# Memorandum

**To:** Joe Shaffer  
**From:** Mike Nugent/Manager of Inspection Services  
**Date:** 04/14/2004  
**Re:** 364 Forest Ave (114A F001)

I have Commenced reviewing the plans for Permit # and have the following questions:

DRIVING NUMBER: B101  
REVISION: 0

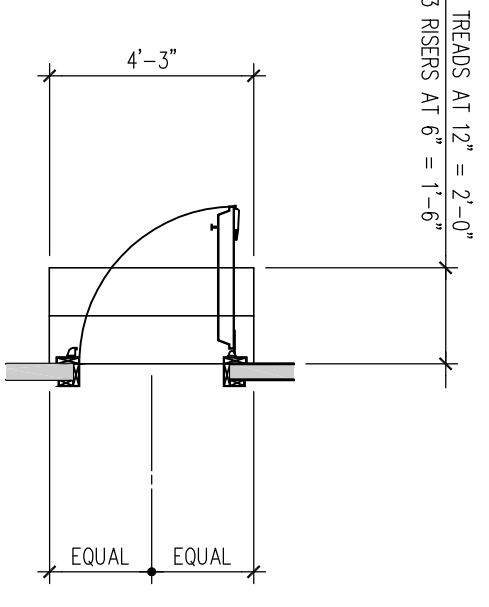
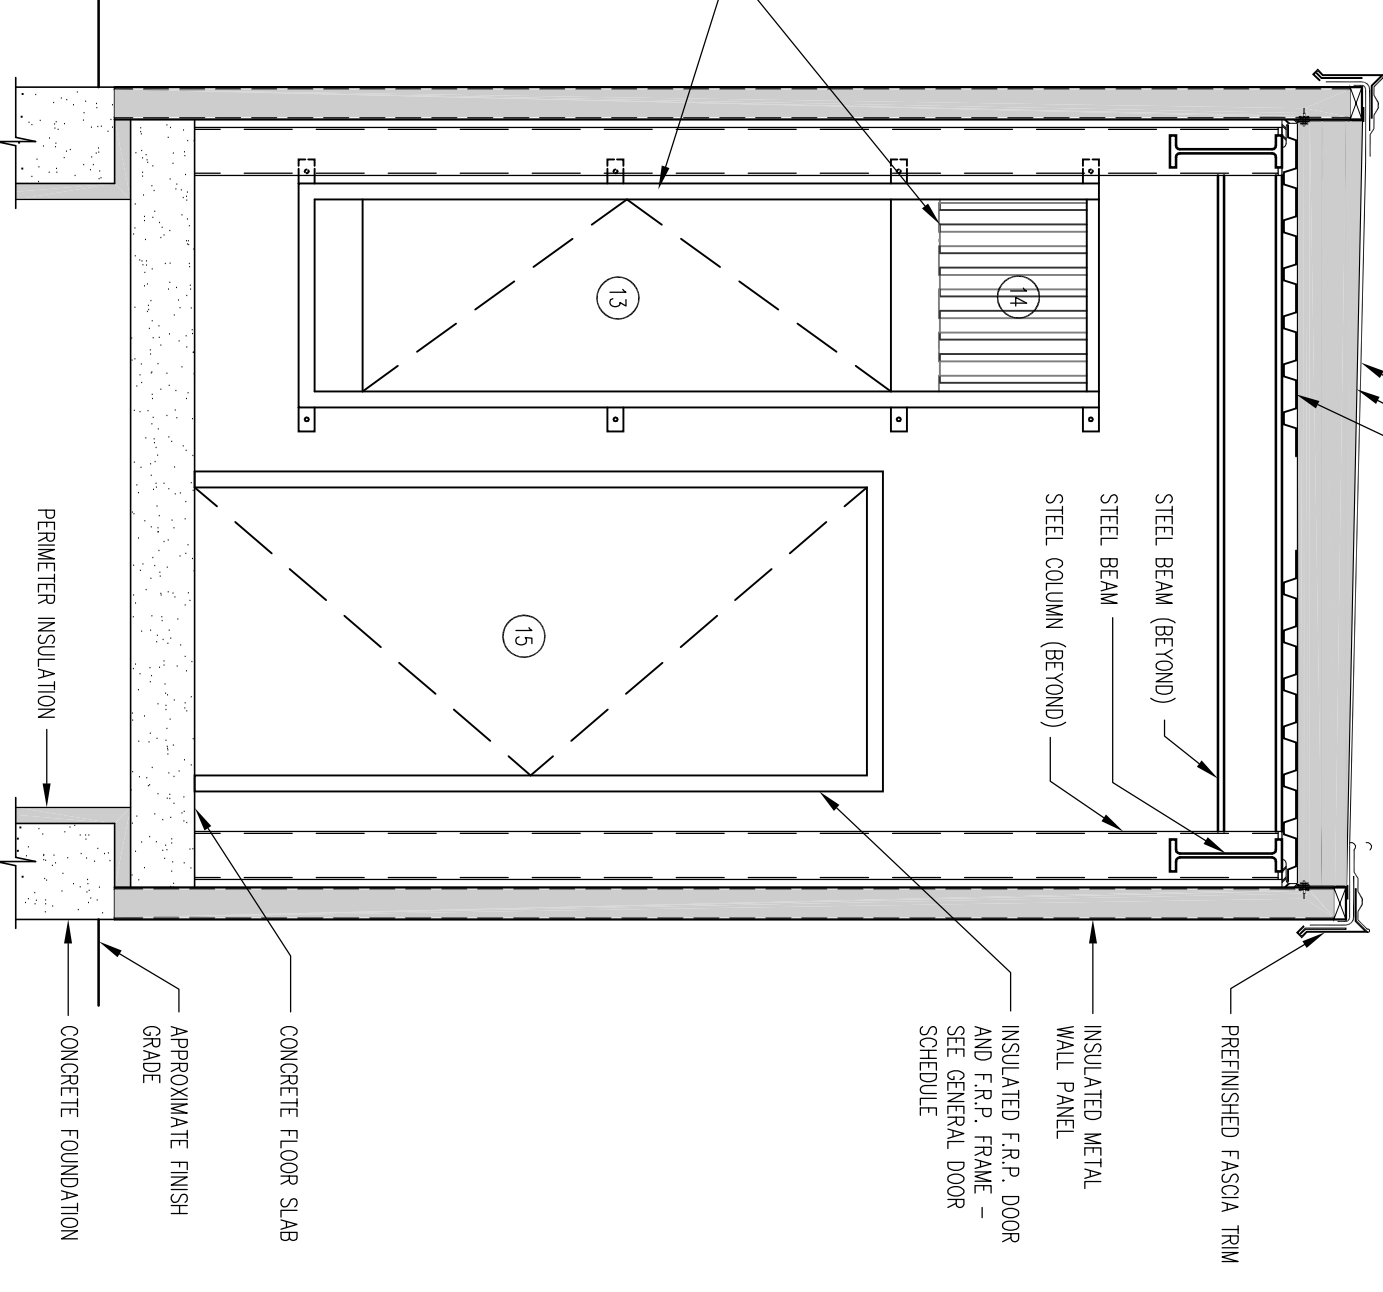
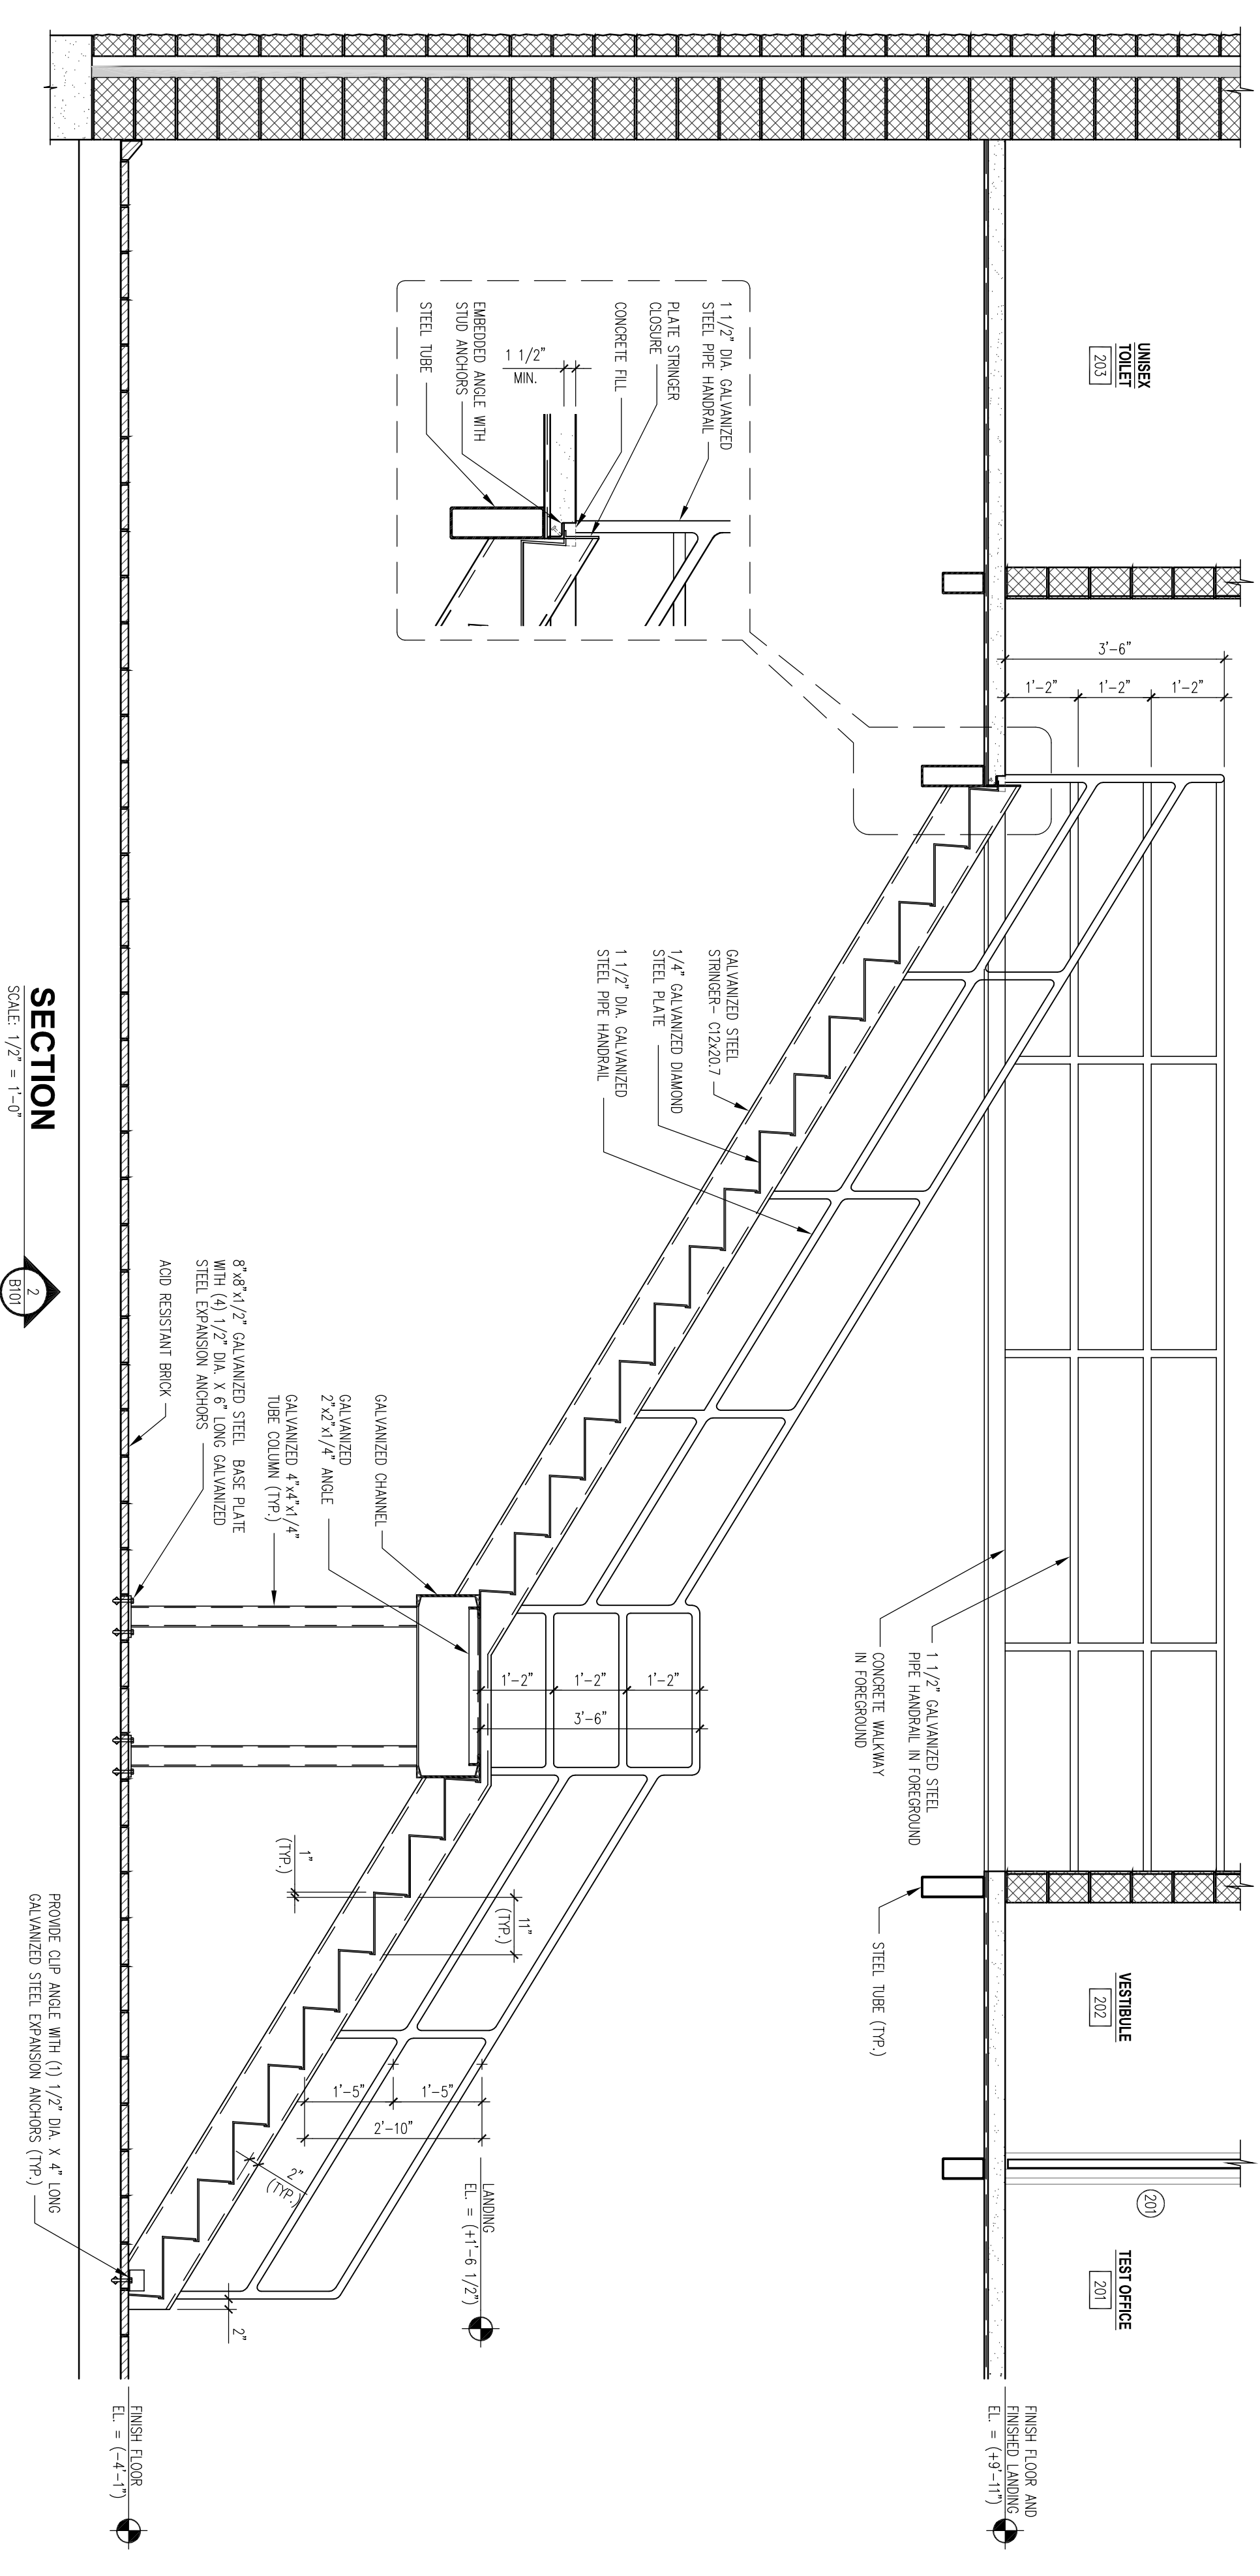
1. On page B101 the handrail on the “enlarged First Floor” plan does not extend 1 foot beyond the top tread.
2. Exterior stairs guards appear to be 36 inches not 42 inches, and need tread and riser dimensions
3. Exterior stairs in climates subject to snow or ice must be protected (section 1014.12)
4. The referenced standard in the Code for Engineered Masonry design is Chapters 1 through 8 of ACI 530.1/ASCE 5/TMS 402, the job spec book cites ACI 530.1/ASCE 6/TMS 602 can you advise?
